November 29, 2024

**Re: Response to Technical Comments – SPC Application D07-12-24-0087; 2900 Brian Coburn Blvd./119 Ryan Reynolds Way**

SEYMOUR PACIFIC Developments Ltd.

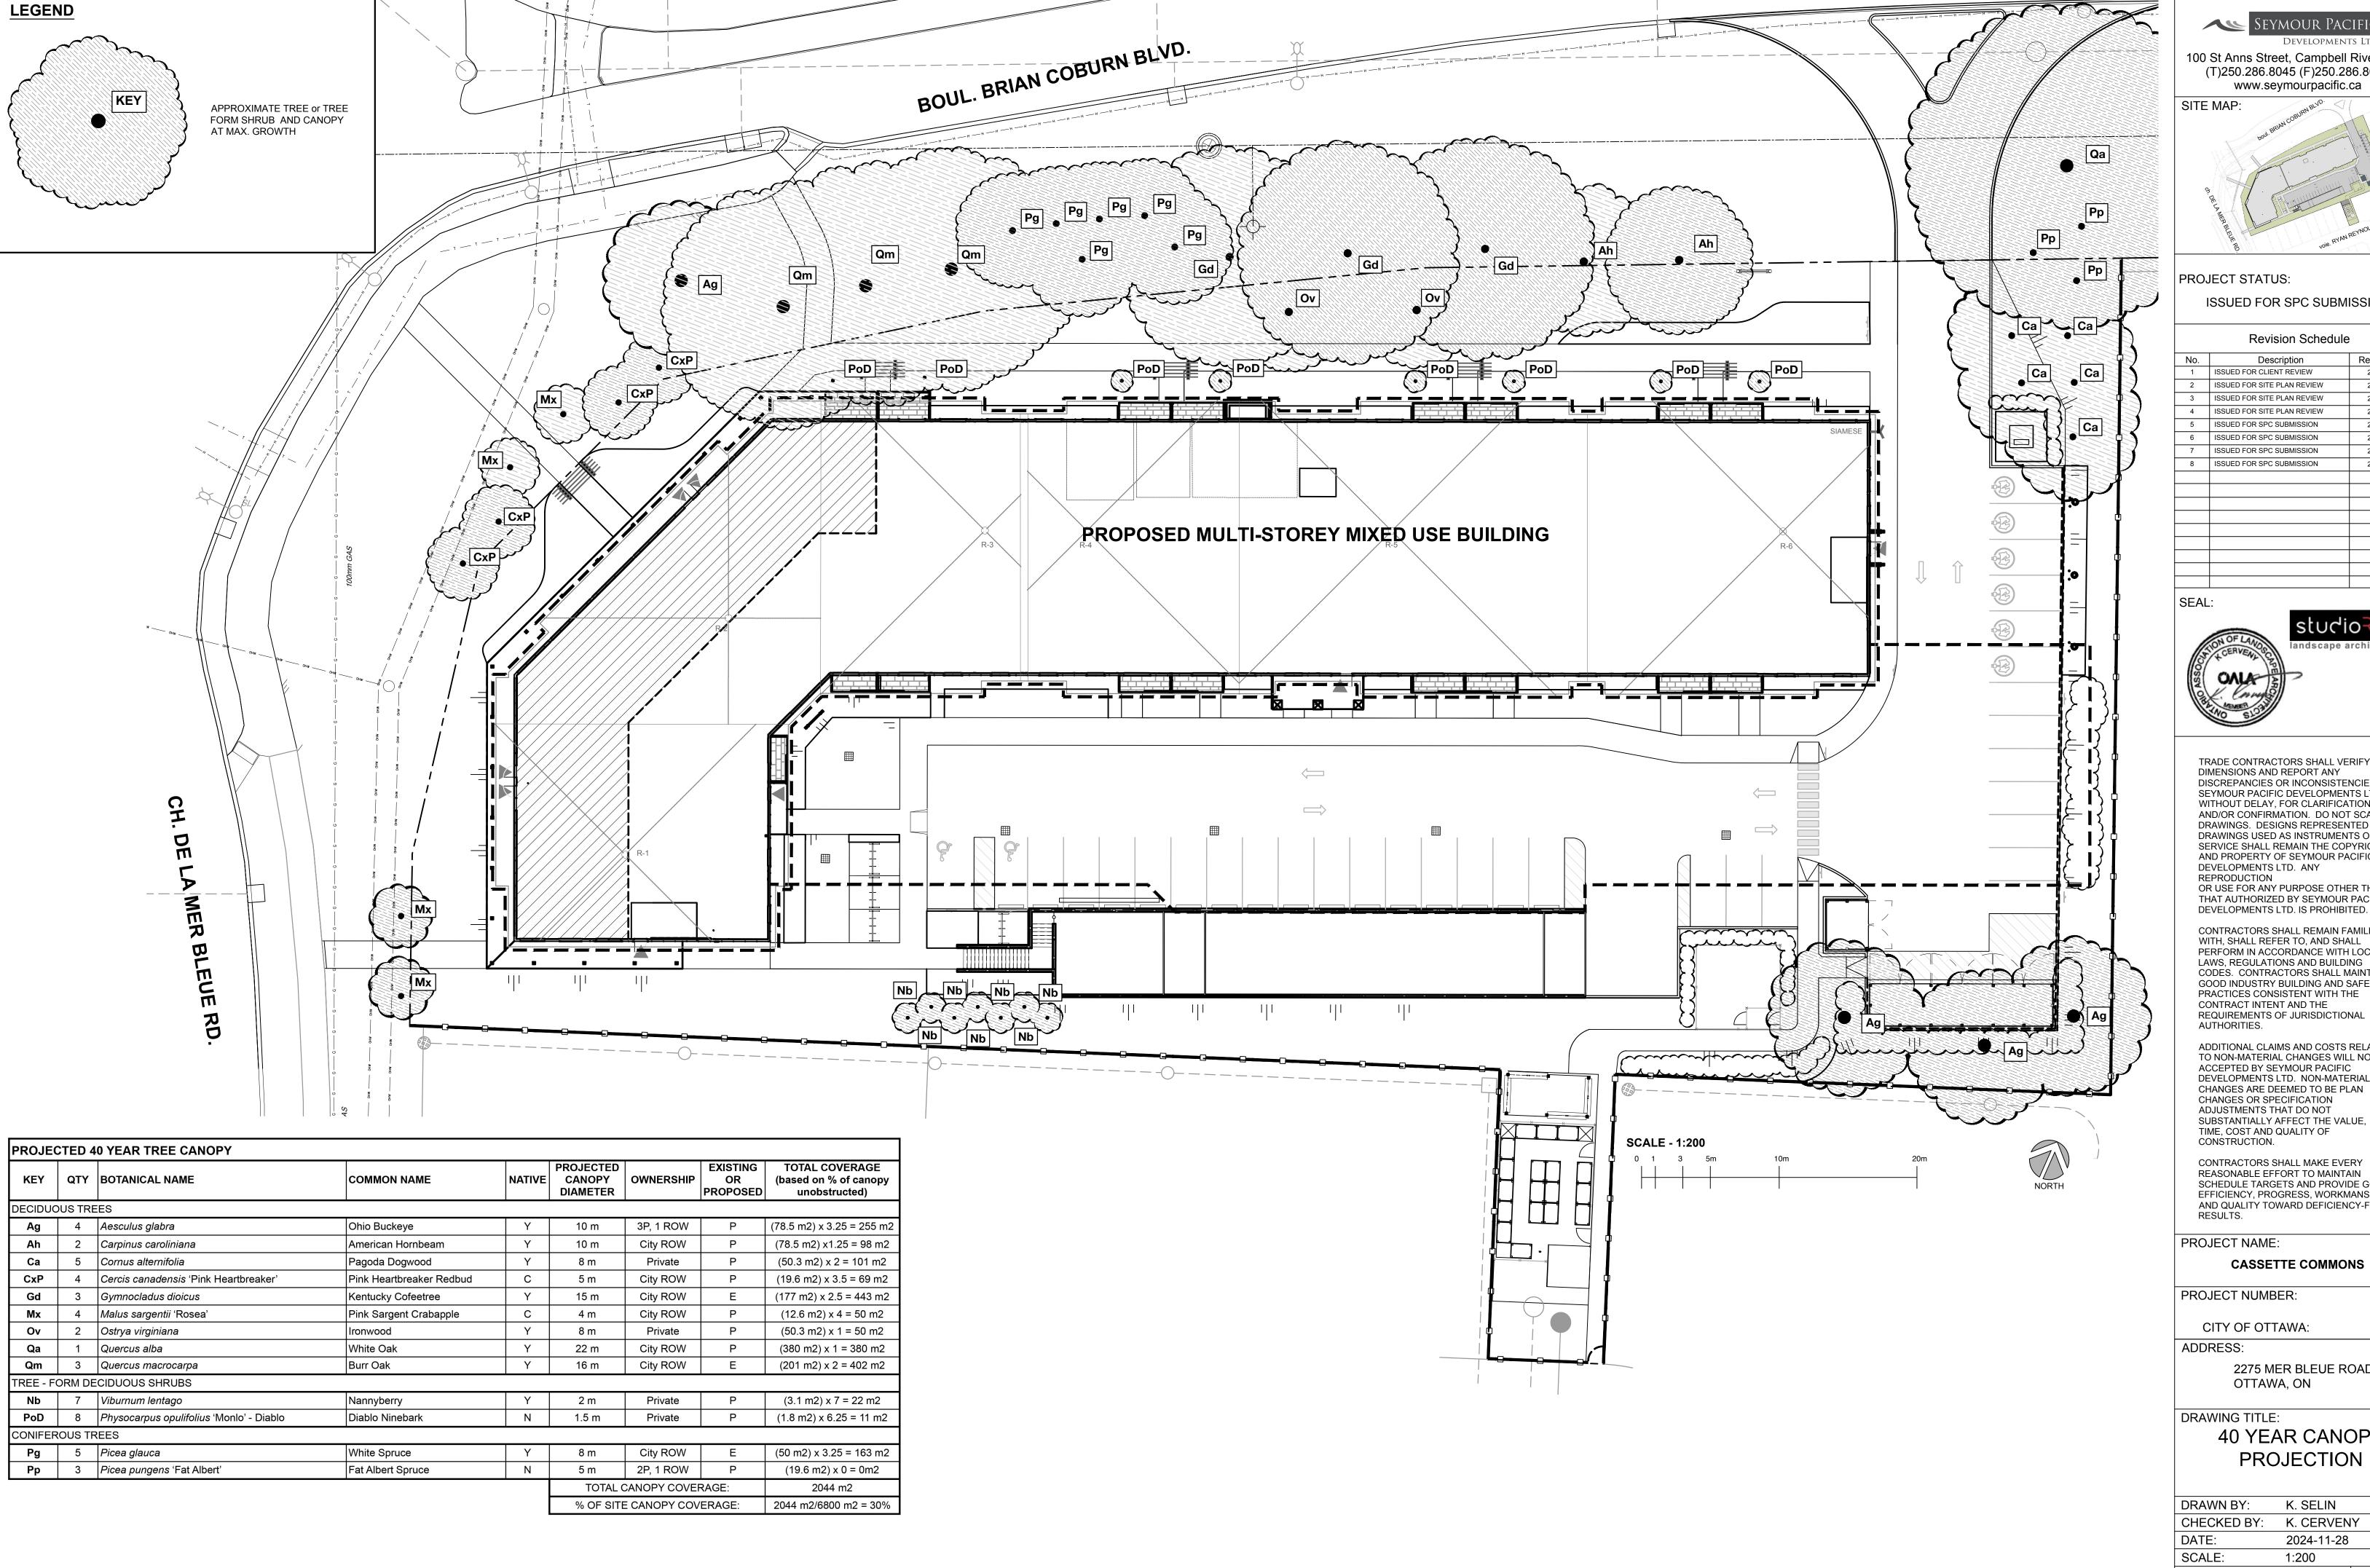
3. The private fire hydrant should connect to the private watermain to avoid multiple connections into the municipal infrastructure.	Noted. Please refer to the revised plans. The hydrant is now connected to the proposed service and isolated by valves such that the building feed can be disconnected while maintaining flow to the hydrant.
<b>II. Forestry</b>	
Comments:	
<p>4. Why doesn't the tree planting setback apply to the south side of the building? There is less than 7.5m from the trees to the building in this area. Photo included for reference:</p> 	The tree planting setback does apply so all proposed trees have been replaced by native shrubs.
